Our ref: NO/2020/112543/02-L01
Your ref: 3/2020/0112
Date: 22 June 2020

**DEMOLITION AND REBUILD OF EXISTING DWELLING AND ERECTION OF NEW
ADDITIONAL DWELLING.
GLENCROFT, PENDLE AVENUE, CHATBURN, BB7 4AX**

Environment Agency position

New Dwelling Ground Floor Plan as Proposed
 Scale 1:50

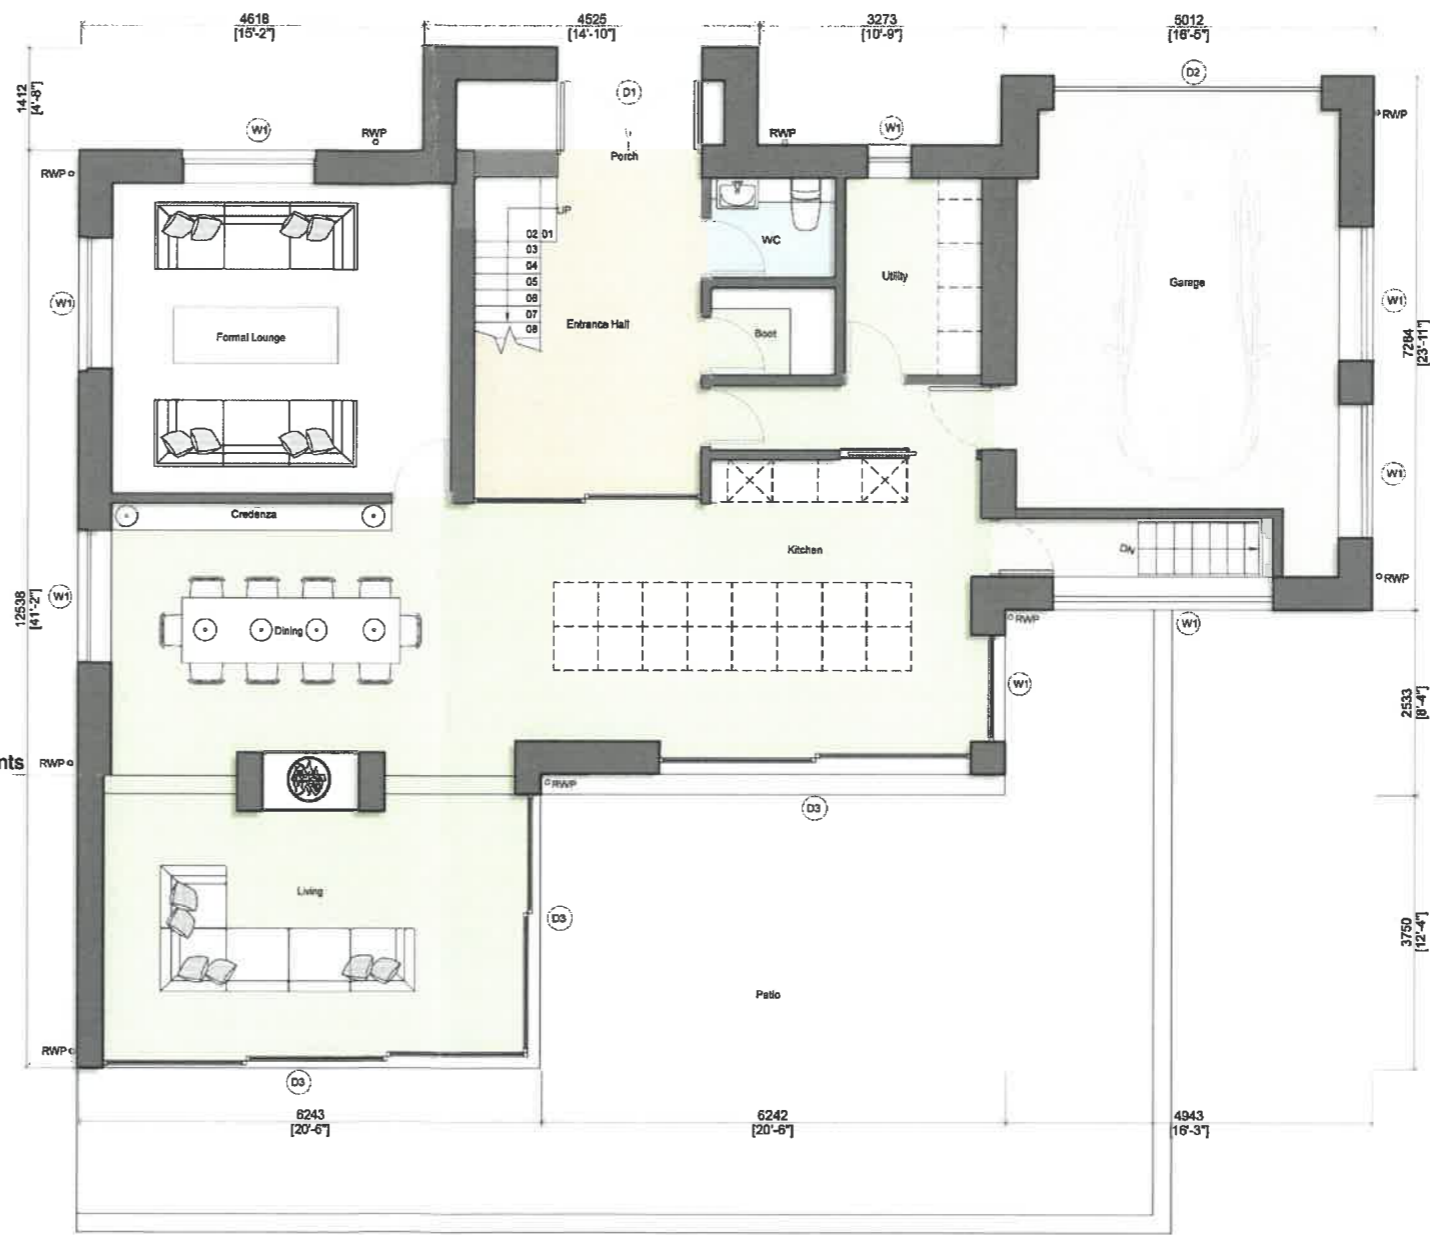
The FRA has outlined the finished floor levels of the extension of the existing dwelling will be the same as the existing building, this is considered to be acceptable. The proposed dwelling will have finished floor levels of 102.76mAOD, this provides 300mm above the 100-year and 1,000-year return period levels. The 100-year and 1,000-year return period extents for the proposed dwelling are about the same, as such we would

expect the FFLs to be, as a minimum of whichever is higher of:

- 300 millimetres (mm) above the general ground level of the site
- 600mm above the estimated river or sea flood level

The FFL for the proposed dwelling does not comply with this.

To overcome our objection, the applicant should submit a revised FRA which addresses the points highlighted above.
